Application by National Grid Electricity Transmission (NGET) for a Development Consent Order (DCO) for the proposed Norwich to Tilbury Project (Application Reference: EN020027).

Essex County Council (ECC) Norwich to Tilbury Deadline 6 Submission.

Figure 1: Location of Mitigation Areas 113a&b, 114, 115

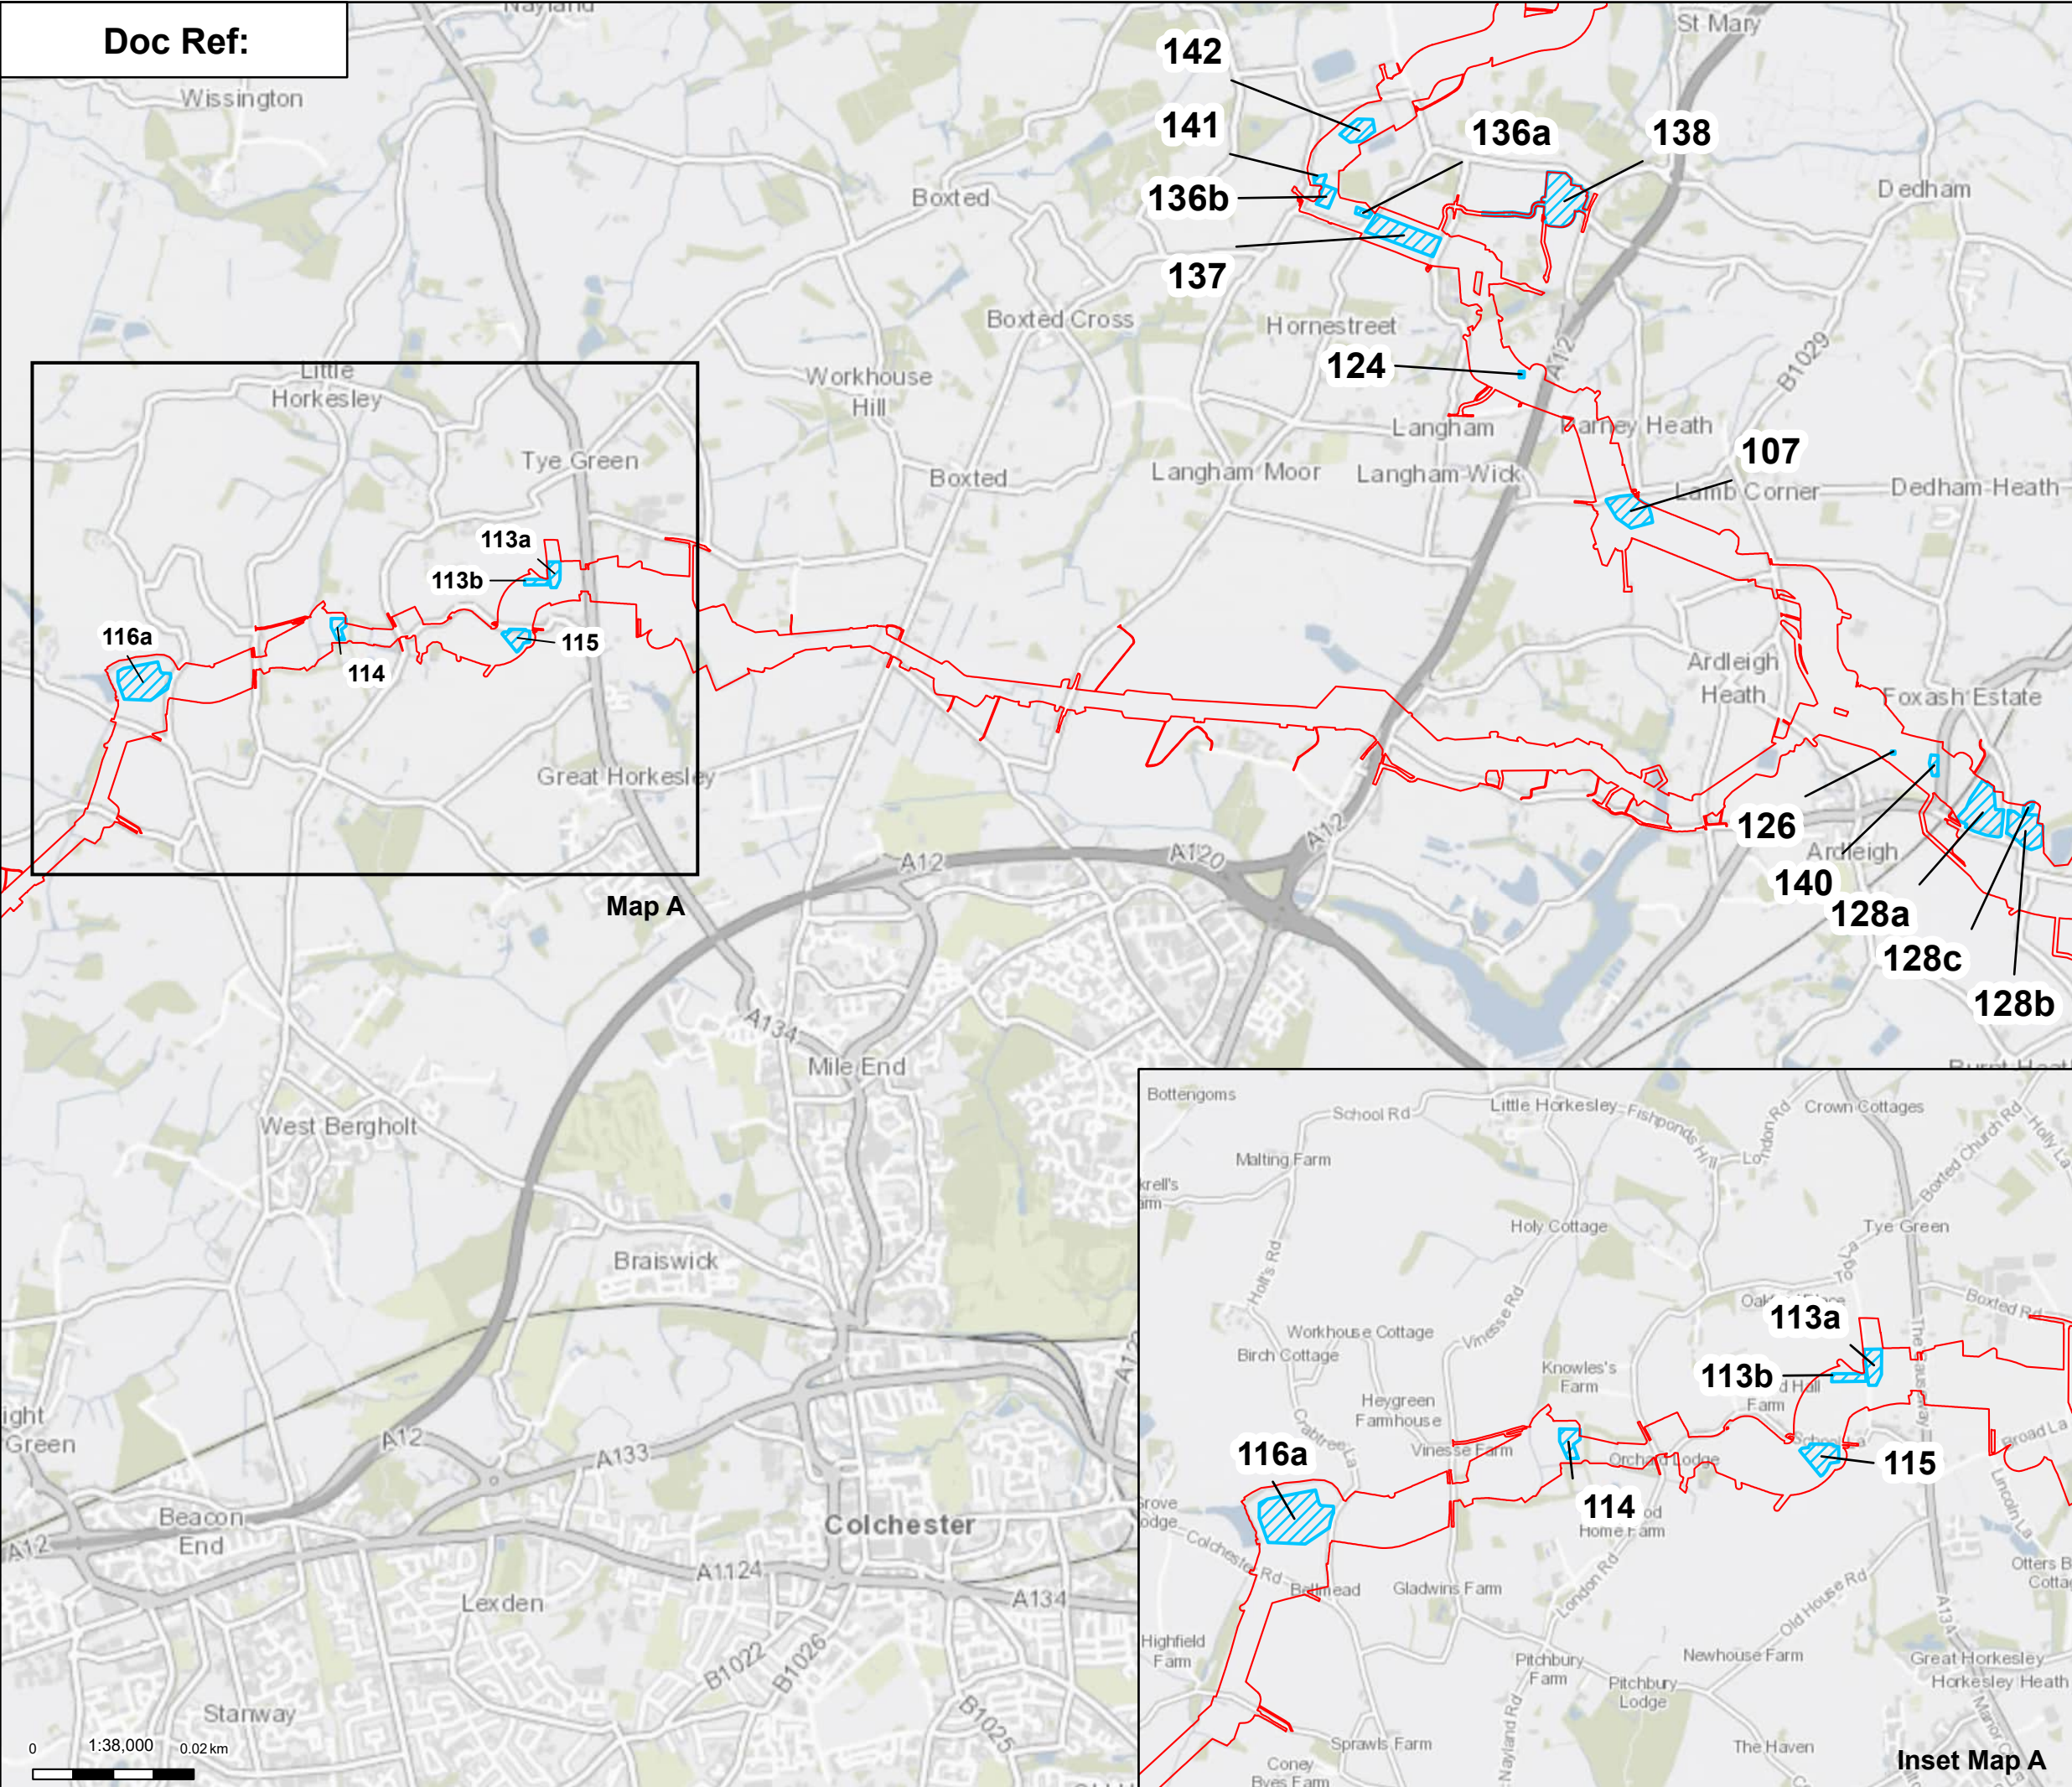
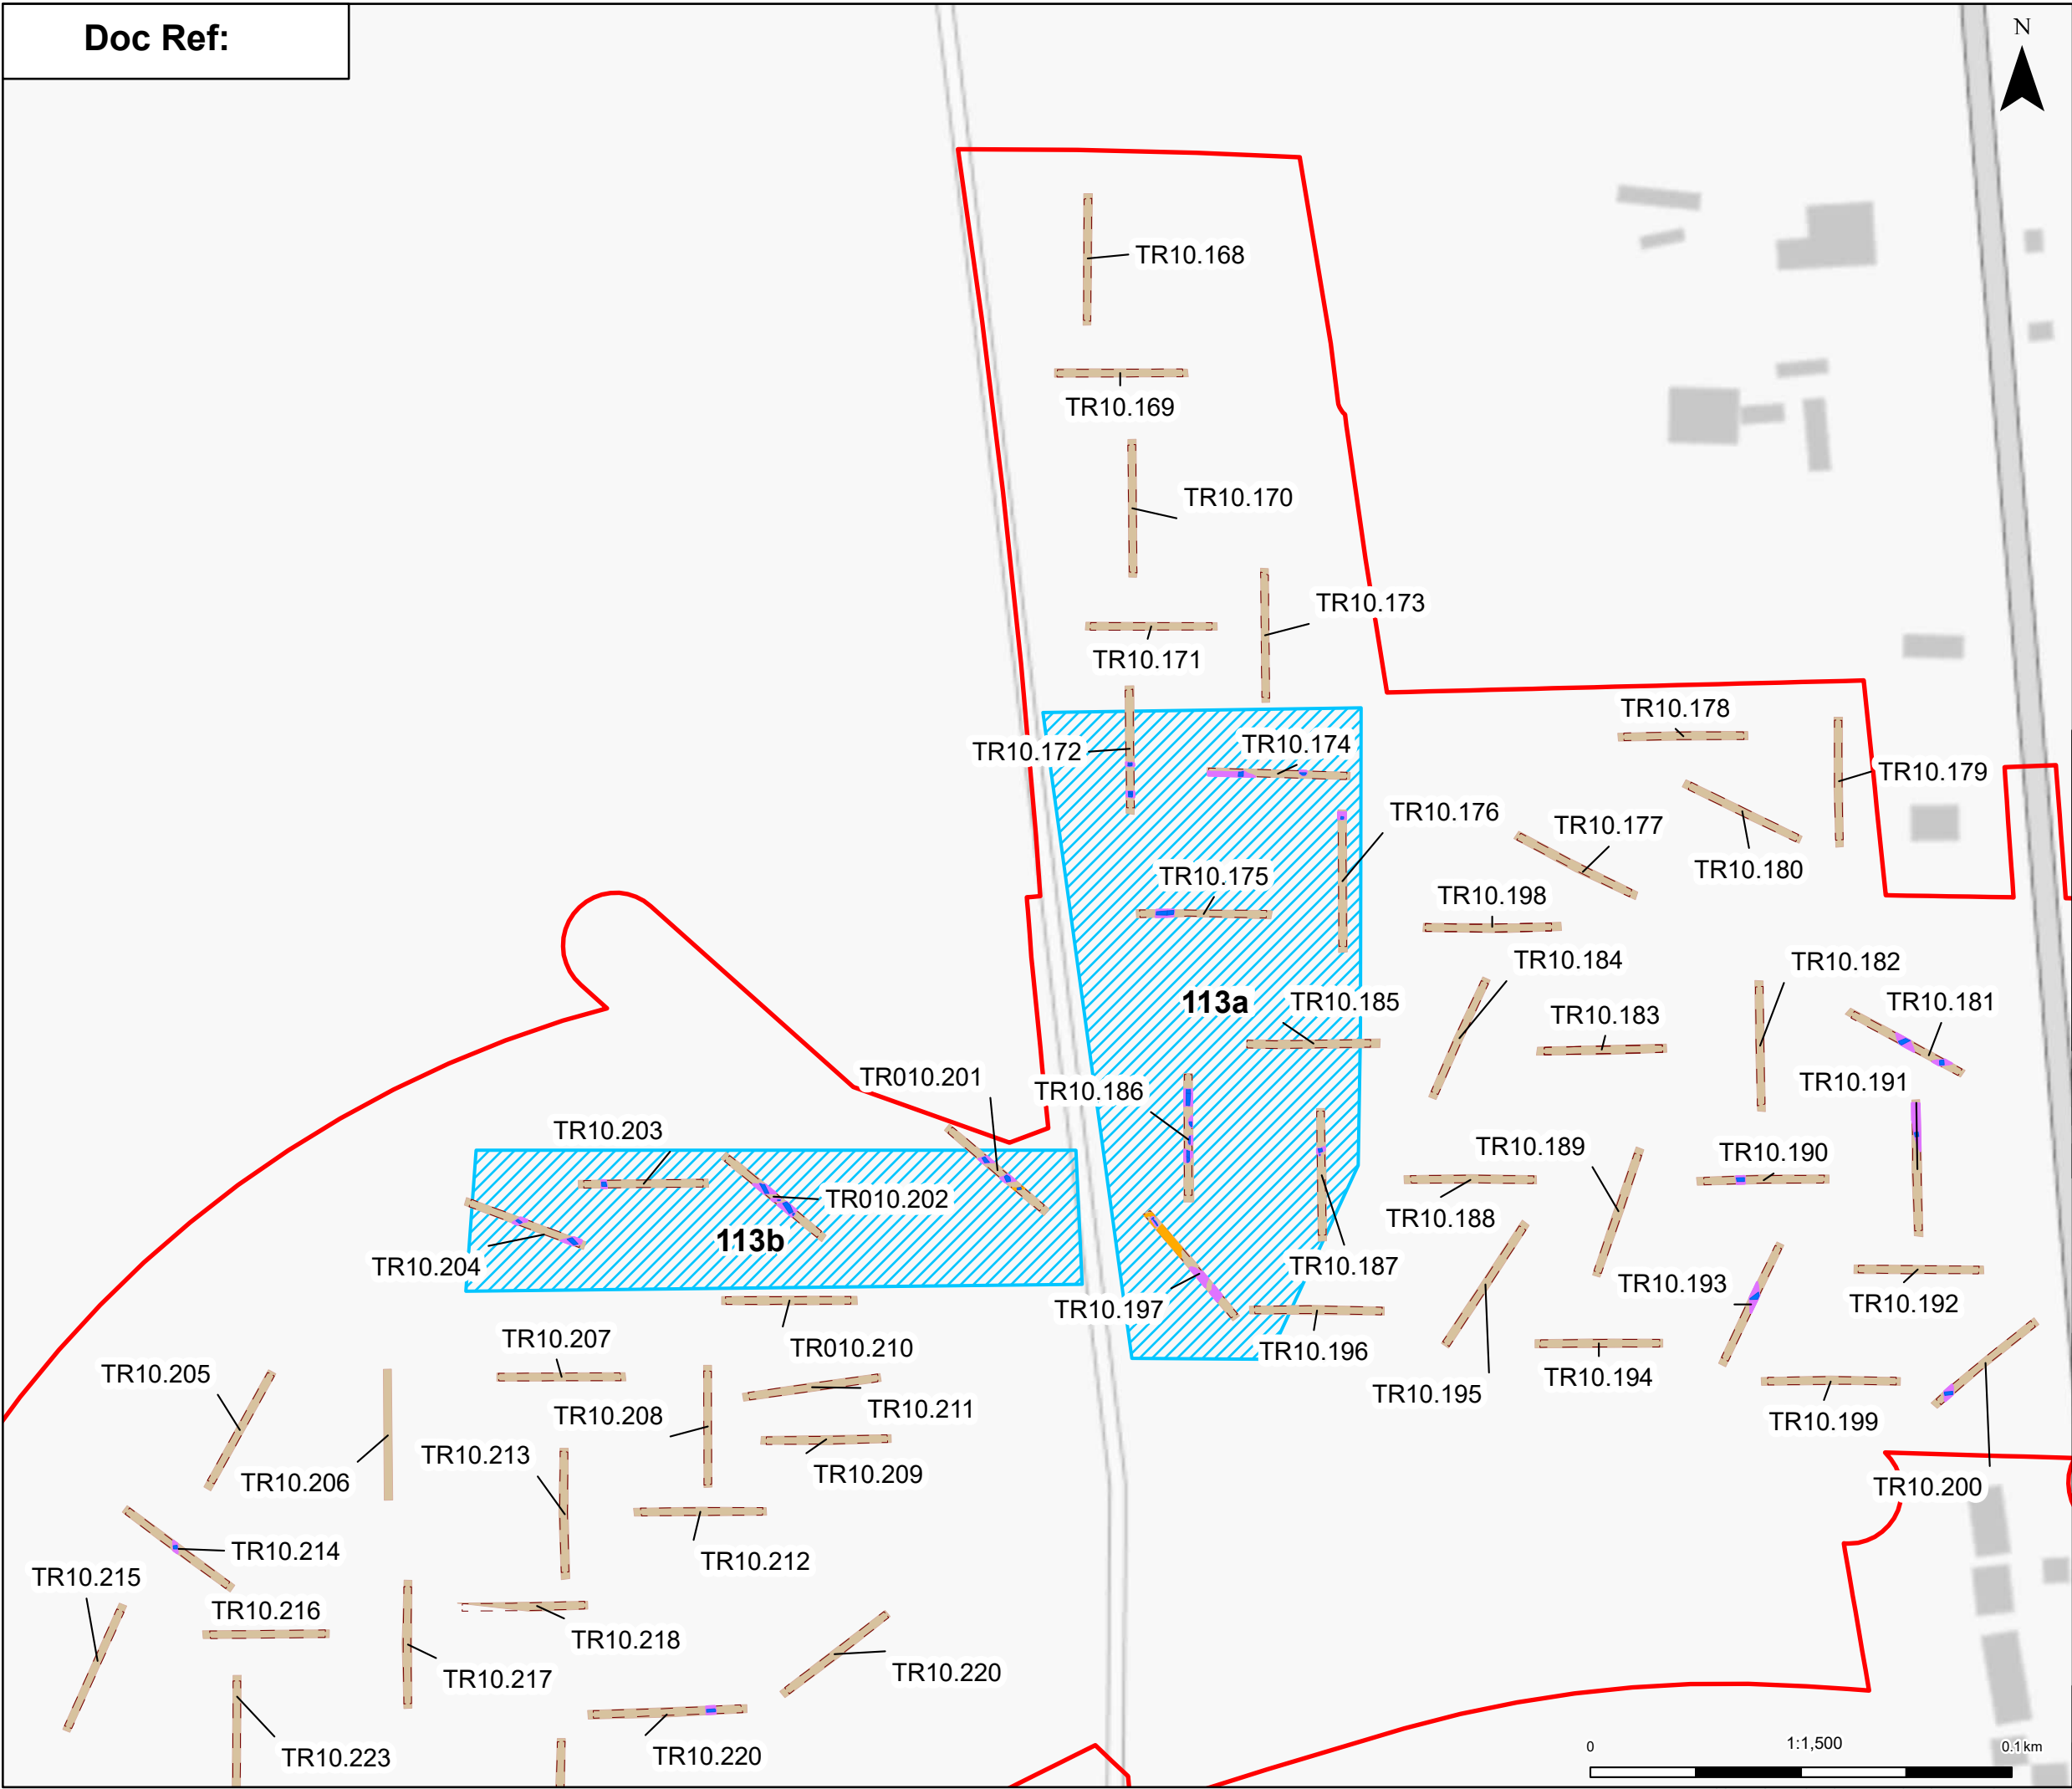
- 8.21 Detailed Written Scheme of Investigation – Mitigation areas 124, 136 (a & b), 137, 138, 141 & 142 Final Issue A (REP5-220)
- 8.22 Detailed Written Scheme of Investigation – Mitigation areas 126, 128 (a, b & c) & 140. Final Issue A (REP5-221)
- 8.23 Detailed Written Scheme of Investigation – Mitigation areas 109, 110, 111, 112 (a & b) & 139. Final Issue A (REP5-222)
- 8.24 Detailed Written Scheme of Investigation – Mitigation areas 113 (a & b), 114 & 115. Final Issue A (REP5-223)

1.32. The documents submitted are not acceptable in their current form, further information has been requested directly to the Applicant to facilitate full consideration of the mitigation proposals. The sites proposed for mitigation have not yet been discussed or approved by the archaeological advisor and there has been limited time since submission to consider these documents. It is considered inadvisable to secure mitigation at this stage of the application due to time constraints.
